M54 to M6 Link Road

**8.8P(C) Draft Statement of Common
Ground with Historic England**

**8.8P(C) Draft Statement of Common Ground with
Historic England**

Version	Date	Status of Version
5 (P06)	8 January 2021	Issue to the ExA for Deadline 4

FIGURE 2.6
DRAFT ENVIRONMENTAL
MASTERPLAN
SHEET 4 OF 5

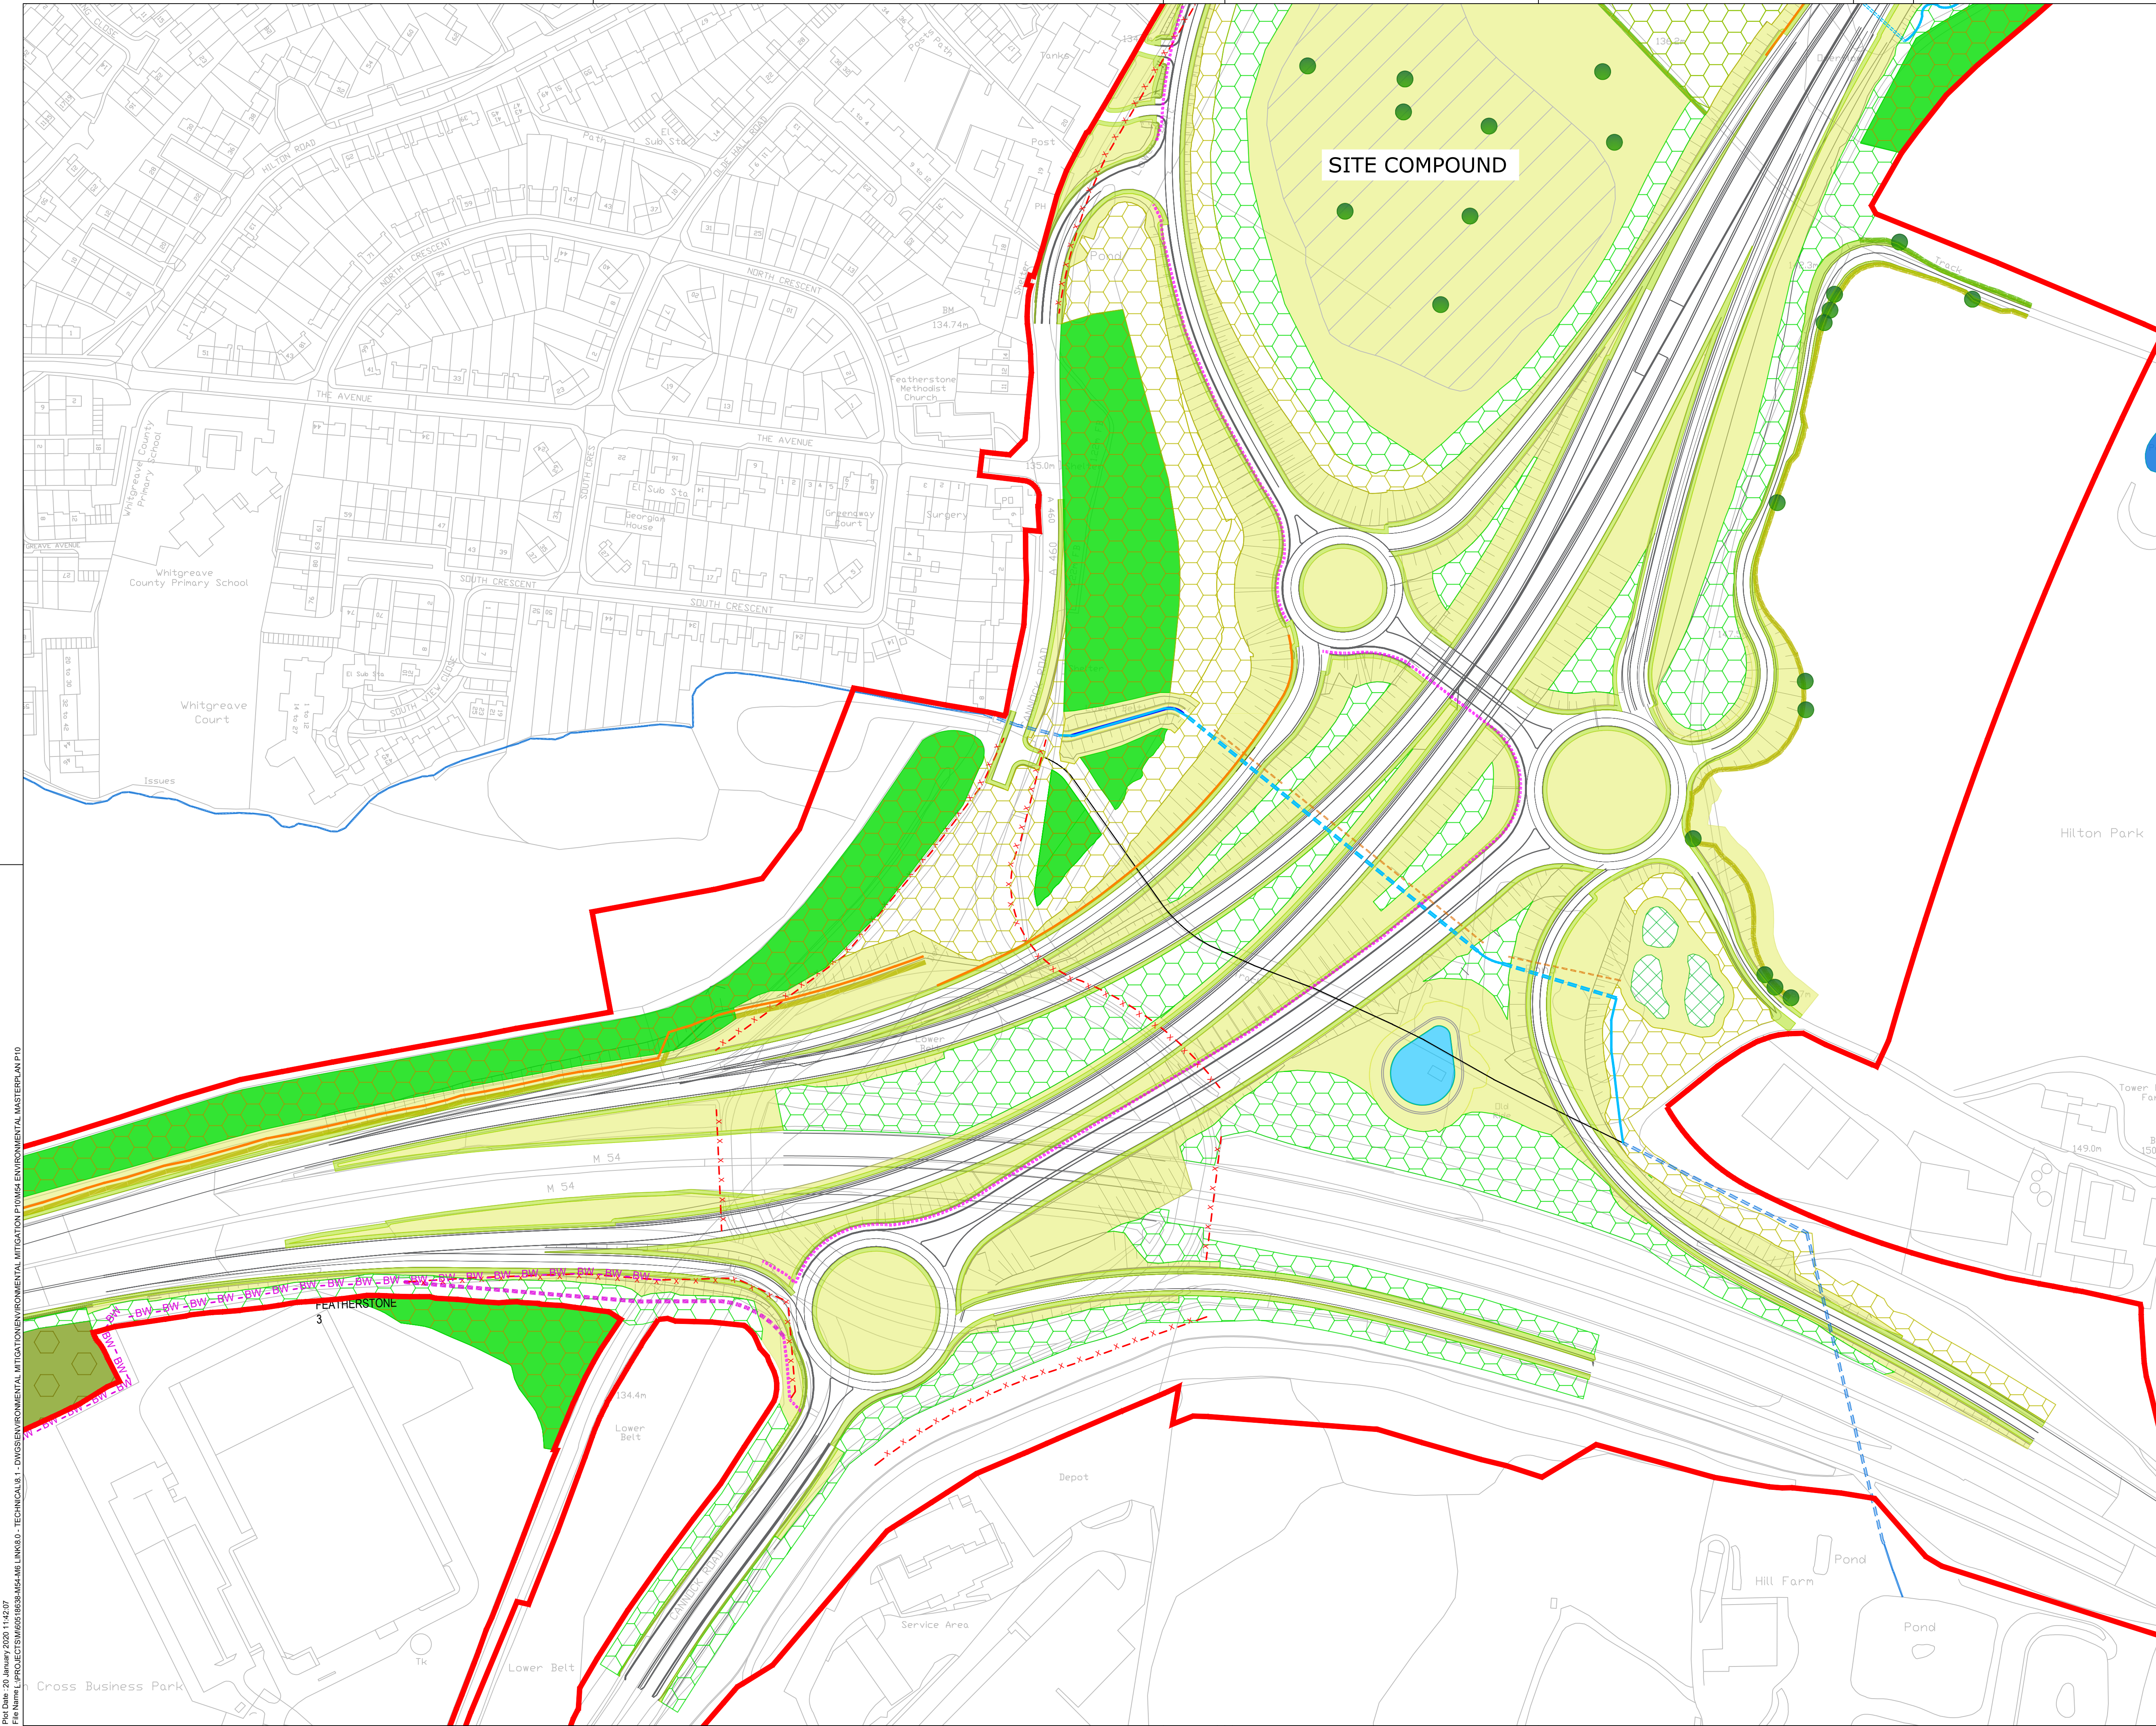
20/10/2020	Email from BK (Historic England) to TP (AECOM)	<p>Email in response to enquiry made by TP (AECOM) on 21/05/2020 regarding a request from a landowner to move mitigation measures intended to reinforce the designed landscape parkland of Hilton Park (species-rich grassland and individual trees), from the east of the Scheme to the west of the Scheme north of Tower House Farm.</p>
21/10/20	Email from BK (Historic England) to TP (AECOM)	<p>Requested minor amendments to the meeting minutes.</p> <p>Comments on the SoCG.</p>
04/11/20	Email from TP (AECOM) to BK (Historic England)	<p>Sent version of the SoCG submitted to the ExA at Deadline 1 (03/11/20) alongside new photomontages taken from the ground, first and second floor of Hilton Hall facing towards the Scheme.</p> <p>Request for comment on the photomontages. A meeting can be set up to discuss this issue further if required.</p>
30/11/20	Email from TP (AECOM) to BK (Historic England)	<p>Request comments on the Photomontages in relation to the outstanding issues in the SoCG.</p> <p>Inform Historic England that the 'designated fund' application for the feasibility study to restore Portobello Tower has been rejected.</p>

Viewpoint number: 16B
Location title: View from Hilton Hall looking south
Camera model: Canon EOS 6D
Focal length: 50mm
Field of View: 65° (Horizontal)
Camera height: 1.6m
Photo taken: 17/12/2019
Coordinates: 395197, 305181
Elevation: 156m AOD

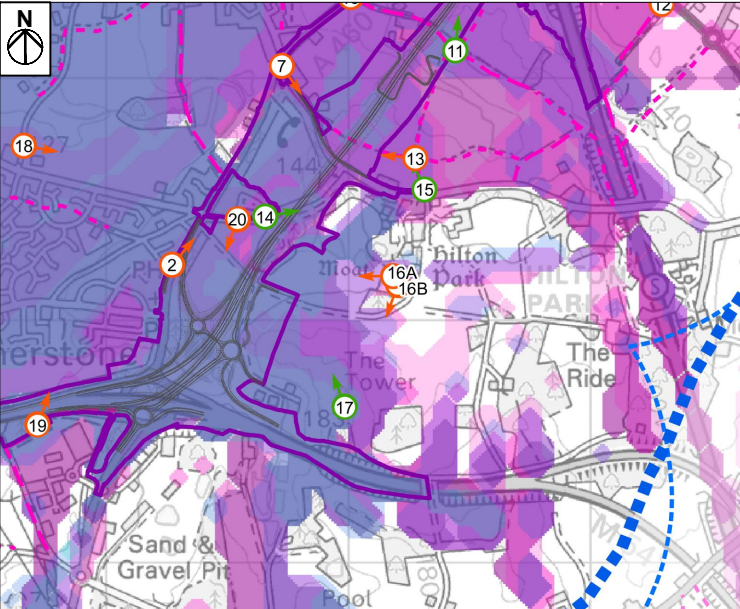
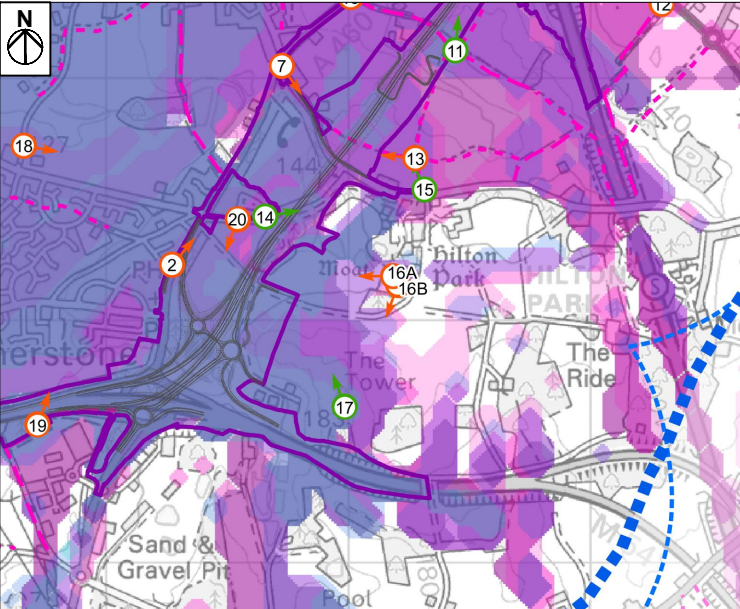
ES Chapter	Paragraph Reference	Sub-section	Historic England Comment	Highways England Response	Status	Agreement likely? ¹
			exception being further comments regarding Hilton Hall and the Conservatory; see the row below).		ry' which remain under discussion, see below).	
Chapter 6: Cultural heritage [APP-045/6.1]	Section 6.9 'Assessment of likely significant effects' Para. 6.9.12	Setting of Hilton Hall and the Conservatory	The parties agree that the setting of Hilton Hall and the Conservatory includes the entirety of Hilton Park. Harm to those assets caused by development within their setting will vary depending on the type of development and the location within the Park.		Agreed	Agreed
Chapter 6: Cultural heritage [APP-045/6.1]	Section 6.9 'Assessment of likely significant effects' Para. 6.9.12	Construction impact, Grade I listed building 'Hilton Hall'	<p>Historic England query the assessment of impacts on Hilton Hall without it being evidenced that the Scheme would be screened from the hall by existing vegetation. The impact would be considered by Historic England to be at least moderate rather than minor ("Partial loss or alteration to a heritage asset's significance and/or its setting. Addition of new features that partially alter setting of a heritage asset to the extent where the significance is impacted.")</p> <p>This assessment is based on the current condition of the planting on the west side of the Moat which is a lot more mature/</p>	<p>Viewpoint photographs Figure 6.5 and 6.6 [APP-076 and 077/6.2] illustrate current views from the hall and have been added to the ES to evidence this.</p> <p>The quotation provided by Historic England is from a superseded version of the DMRB. The current criteria within the DMRB LA104 defines a minor impact as: "Some measurable change in attributes, quality or vulnerability; minor loss of, or alteration to, one (maybe more) key characteristics, features or elements."</p> <p>With a moderate impact defined as "Loss of resource, but not adversely affecting the integrity; partial loss</p>	Under discussion	Medium – pending additional Photomont age.

ES Chapter	Paragraph Reference	Sub-section	Historic England Comment	Highways England Response	Status	Agreement likely? ¹
			<p>overgrown than intended in the original 19th century design.</p> <p>Historic England have subsequently stated that the area of concern is that while views may not be definitely affected, there is impact caused by changes within the park detracting from the parts of the hall's significance caused by its setting. They believe the impact to be greater than slight adverse. However, they do not believe the difference in impact levels to be very great, and it is agreed that the harm is less than substantial. Other options for the alignment here would have resulted in a greater level of impact on Hilton Hall.</p> <p>We note that photomontages are in preparation – but may not be finalised until after Deadline 1 (3rd Nov).</p>	<p>of/damage to key characteristics, features or elements.”</p> <p>All assessments undertaken as part of an Environmental Impact Assessment as reported in the ES are based on the current baseline, not what it was like in the past. It is not possible or accurate to assess the magnitude of impact on what it was like in the 19th century.</p> <p>The assessment of effects on the hall has taken the impact of changes to the park into account. Only part of the park is affected. The impact on Hilton Park has taken into account impacts on individual elements of the asset such as Lower Pool and the Shrubbery as well as lesser impacts on other aspects of the parkland. It is our opinion is that the assessment should remain as slight adverse.</p> <p>A summer view photomontage was provided to Historic England on 4 November 2020. A winter view photomontage is also being prepared and will be provided when complete. Dependent upon the photomontage it may be concluded in this instance that Historic</p>
